Demolition of chalet & erection of 1 No. 4 bedroom chalet (resubmission following
FP/234/17/PL)

10 South Road Felpham

Thank you for your internet representation made on 26th March 2019 which has been recorded as '**an objection**' with the comments as follows:

Elevations

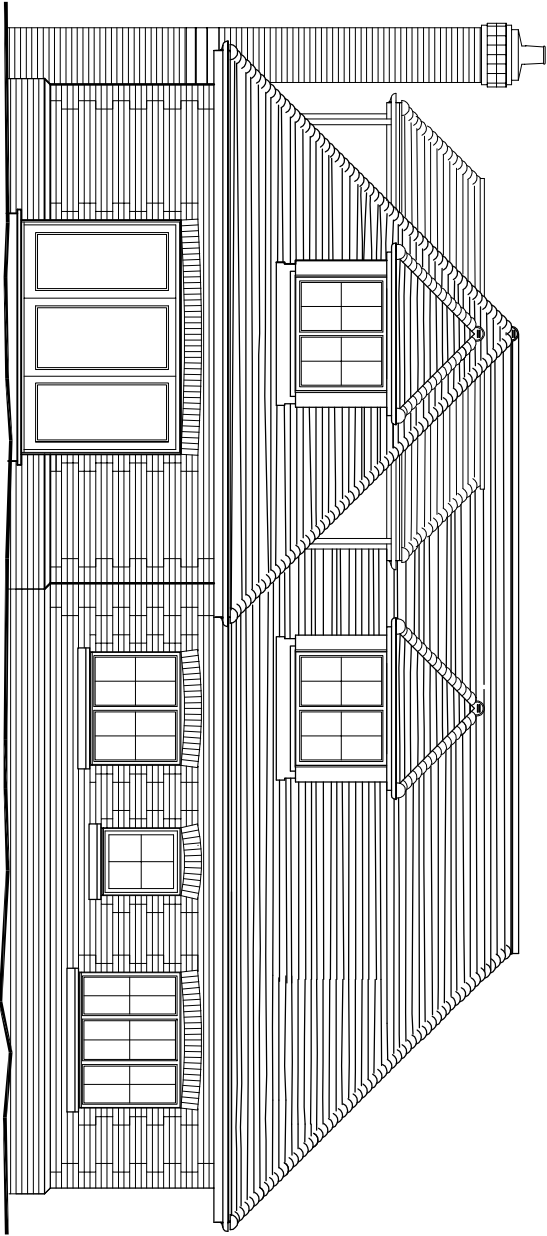
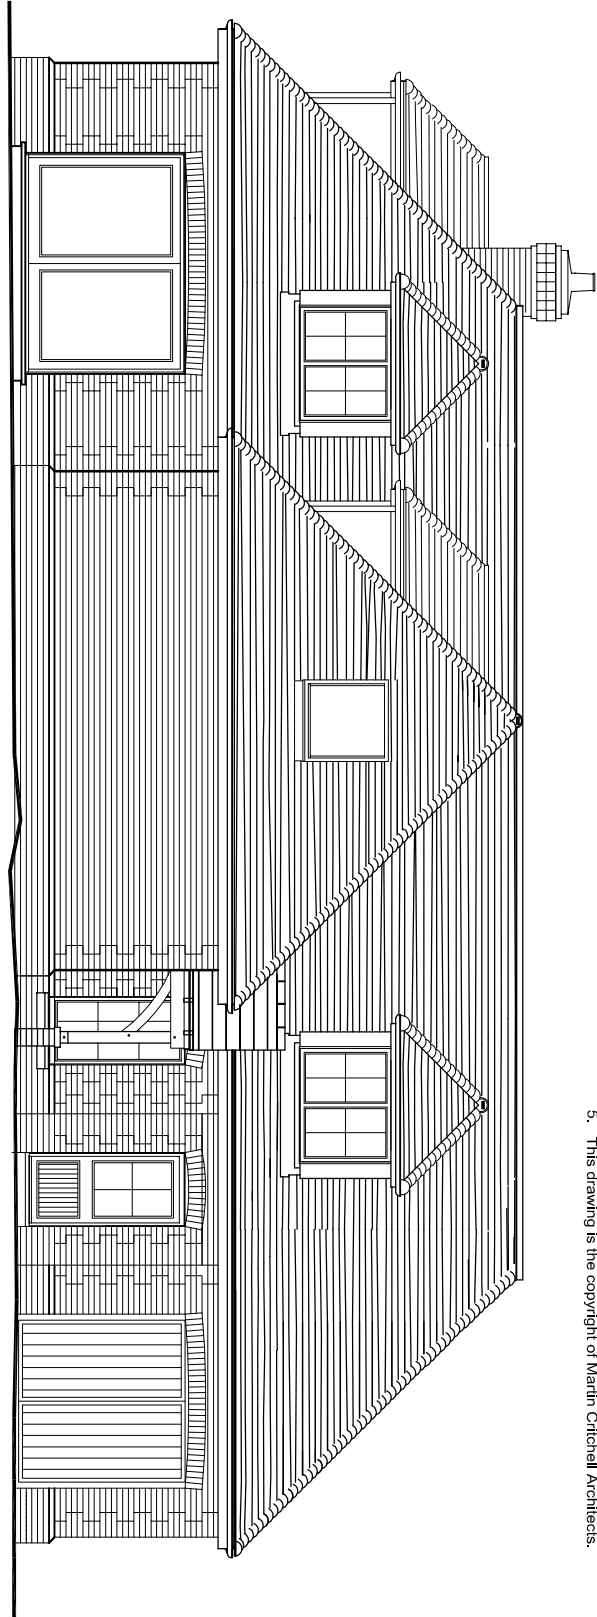
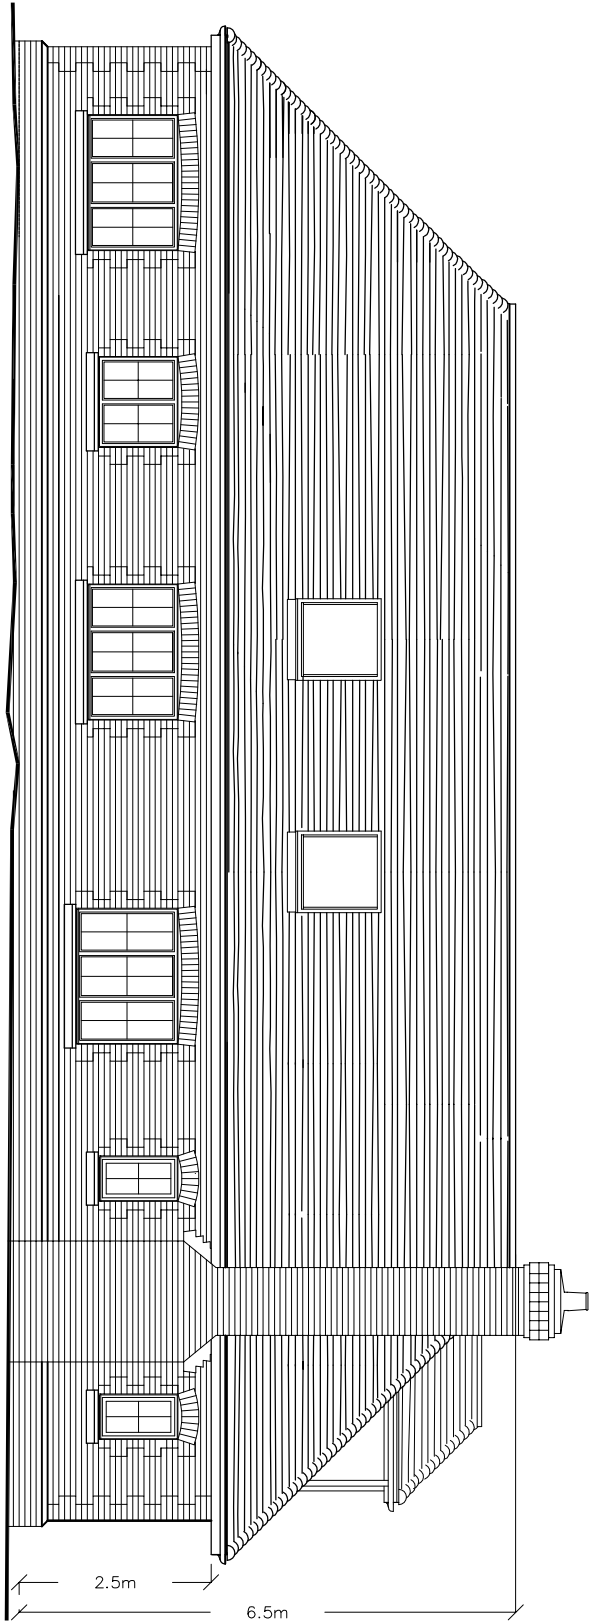
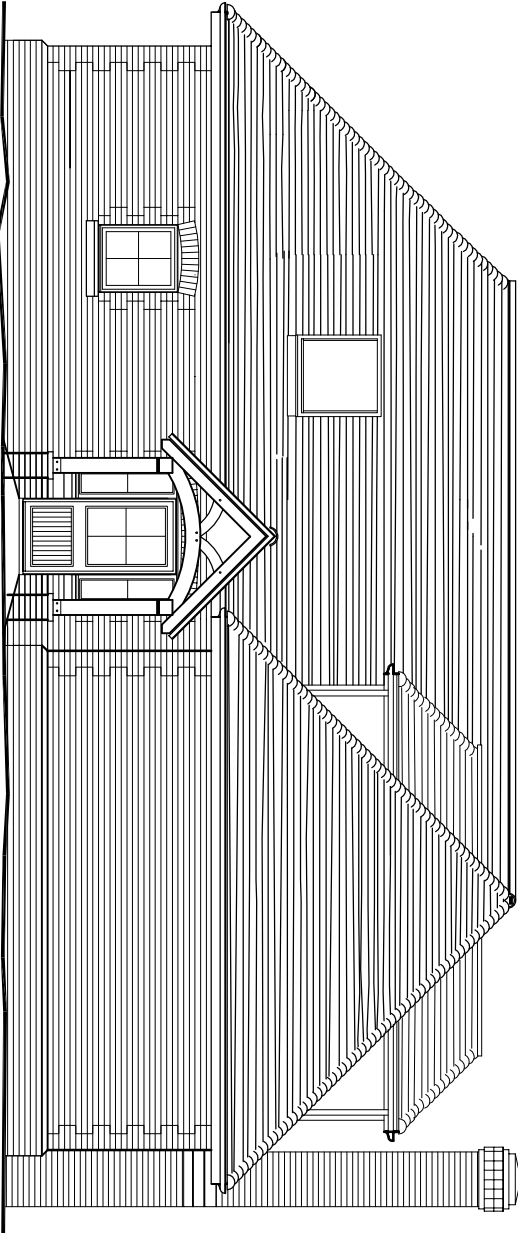
This would be most true for myself, at number 9, since this building (or any further building) will be in what was once my back garden. In particular, the positioning of the proposed property and the location of first floor windows would be highly intrusive, both to the secluded gardens and rear room windows of existing properties. This would seem to be in conflict with policies on the protection of the amenities and privacy of adjoining properties in accordance with planning policies.
